# Rezoning Transportation Analysis

Petition Number: 2024-037

## Revision Log:

Date	Description
4-24-24	First Review (JT)
4-24-24	Second Review (TM)

SCHEMATIC
SITE PLAN

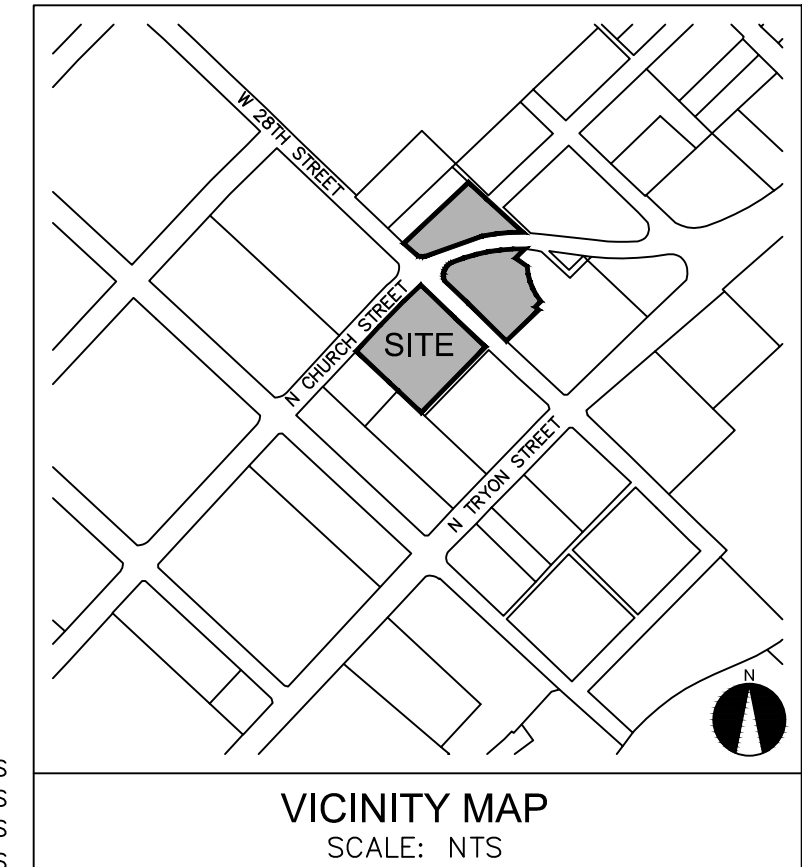
- a. **Church Street:** The future location of curb and gutter is in its existing location.

- b. **W 28<sup>th</sup> Street:** Location of future curb and gutter is to be 17.5 feet from the roadway centerline per CLDSM U-07B.

Label and dimension the curb and gutter from the centerline for each road on the site plan.

3. Revise site plan and conditional note(s) to commit to dedicate 33.5-feet of right-of-way on W 28<sup>th</sup> Street from the road centerline. The site plan shall label and dimension the right-of-way from the road centerline.

4. Revise site plan and conditional note(s) to commit to dedicate 32-feet of right-of-way on N Church Street from the road centerline (or Back of Sidewalk). The site plan shall label and dimension the right-of-way from the road centerline.

5. Revise site plan and conditional note(s) to commit to constructing an 8-foot sidewalk and an 8-foot planting strip along all W 28<sup>th</sup> street frontages.

6. Revise site plan and conditional note(s) to commit to upgrading the Church Street streetscape to an 8-foot planting strip and an 8-foot sidewalk. Per UDO table 33-4 and UDO 32.7.D.B.

7. Revise site plan and conditional notes to commit to upgrading the curb ramps at the intersection of W 28<sup>th</sup> street and N Church street to meet CLDSM standard.

8. Revise site plan and conditional note(s) to commit to providing a cross-access to adjacent parcel per UDO 31.2
9. Add a conditional note specifying "the Petitioner shall dedicate and convey in fee simple all rights-of-way to the City before the site's first building certificate of occupancy is issued. CDOT requests rights-of-way set at 2' behind back of sidewalk where feasible."

10. Revise site plan and conditional notes by remove note C under transportation conditional notes.
  - ISSUANCE OF THE FIRST CERTIFICATE OF OCCUPANCY.
  - C. THE EXISTING CURB SHALL REMAIN ON BOTH N. CHURCH STREET AND W. 28<sup>TH</sup> STREET.
